### **East Anglia One North (EA1N) and East Anglia Two (EA2) Offshore Wind Farms**

**Planning Inspectorate Reference: EA1N – EN010077,  
EA2 – EN010078**

**East Suffolk Council's Responses to the Applicants'  
Deadline 11 Submissions**

**Review of Additional Information Submitted by the Applicants at Deadline 11**

Figure 1 Potential Sensitive Receptors and Areas Subject to Additional Construction Phase Controls

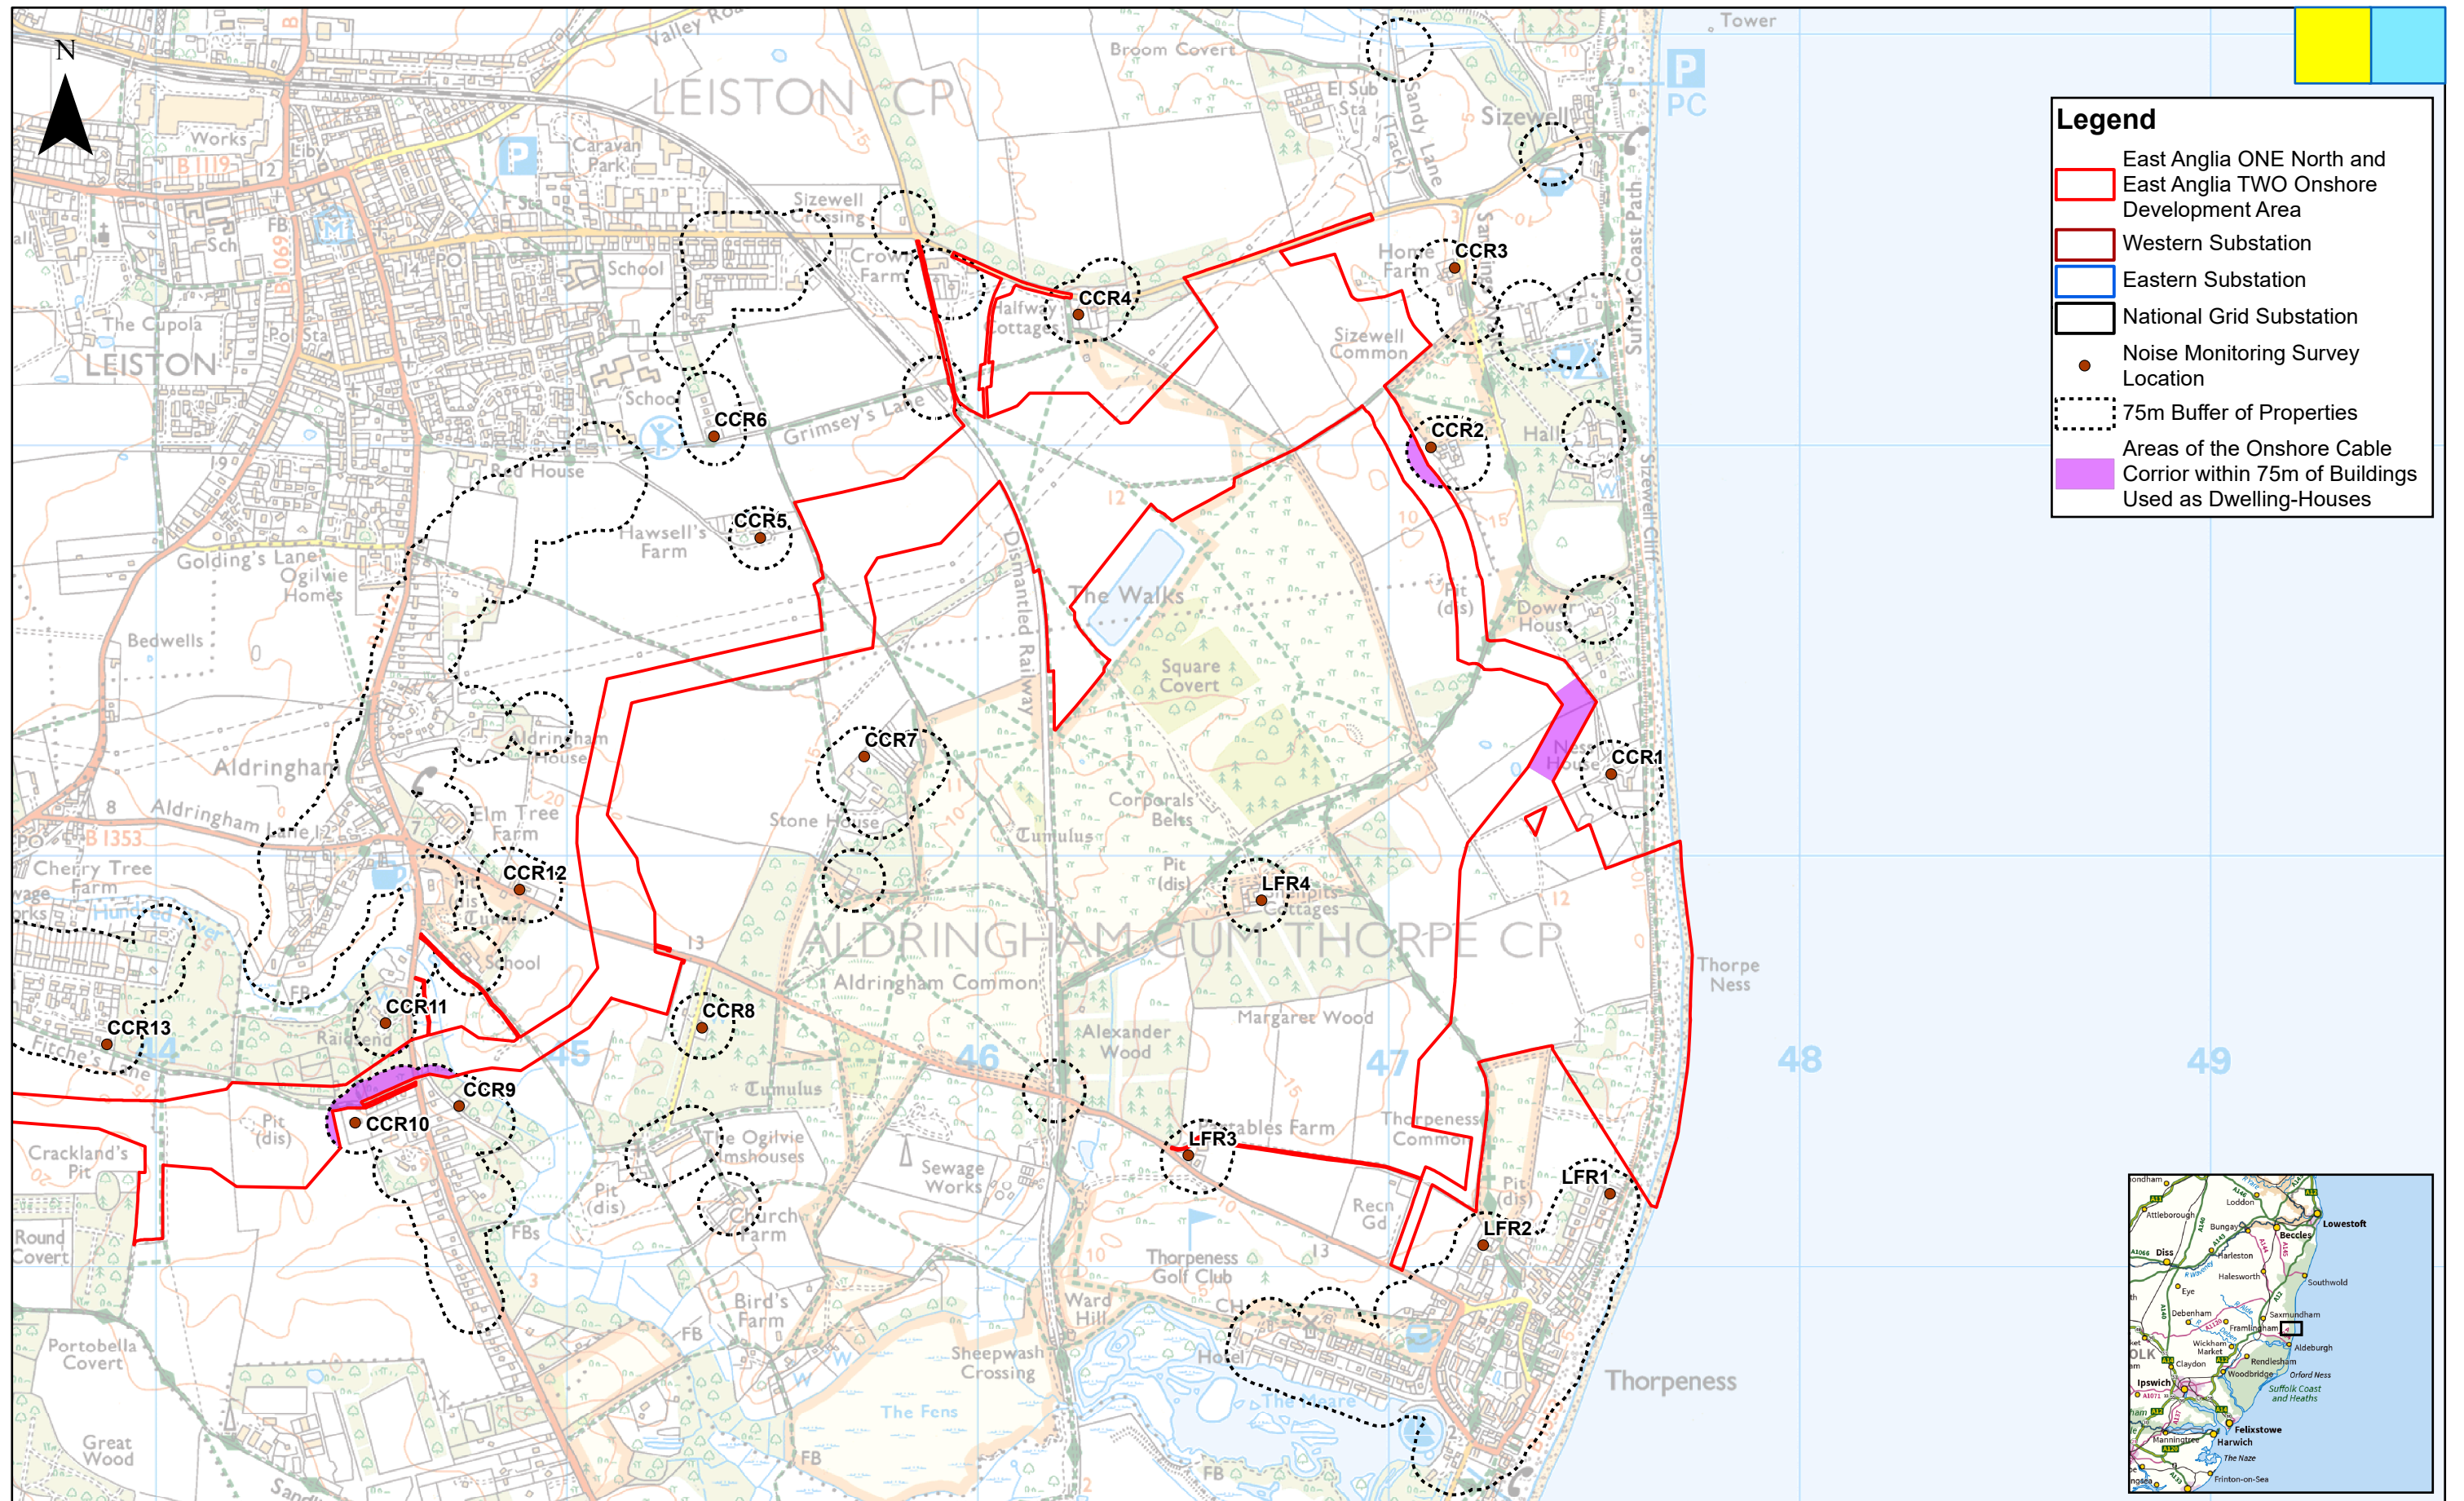
<p>ID26 and ID35</p>		<p>ESC notes that the Outline Code of Construction Practice (OCoCP, REP11-015) states: <i>“Prior to construction, the Applicant will identify the positioning and orientation of plant and equipment involved with the landfall construction in consideration of sensitive air quality receptors where practicable.”</i> ESC has interpreted this as including both natural habitat and human sensitive air quality receptors.</p> <p>This may also be addressed by the Applicants in response to ESC’s Deadline 11 submission (REP11-110) comments in relation to OCoCP paragraph 145.</p>
<p>ID36</p>		<p>ESC previously commented (REP11-110) in relation to paragraph 70 of the Outline Construction Traffic Management Plan: <i>“It would be helpful for this paragraph to confirm that the highest emissions standard vehicles available will be used, and the majority of non-Euro VI HGVs will be Euro V, consistent with the information provided in Section 5.1.5 of the document.”</i> The Applicants responded: <i>“The Applicants will ensure paragraph 70 is amended to align with the text in Section 5.1.5 of the document”</i> (REP11-082). However, the revised text does not reflect ESC’s request, which is important for controlling impacts in Stratford St Andrew. ESC therefore maintains this point. There may however be insufficient time within</p>
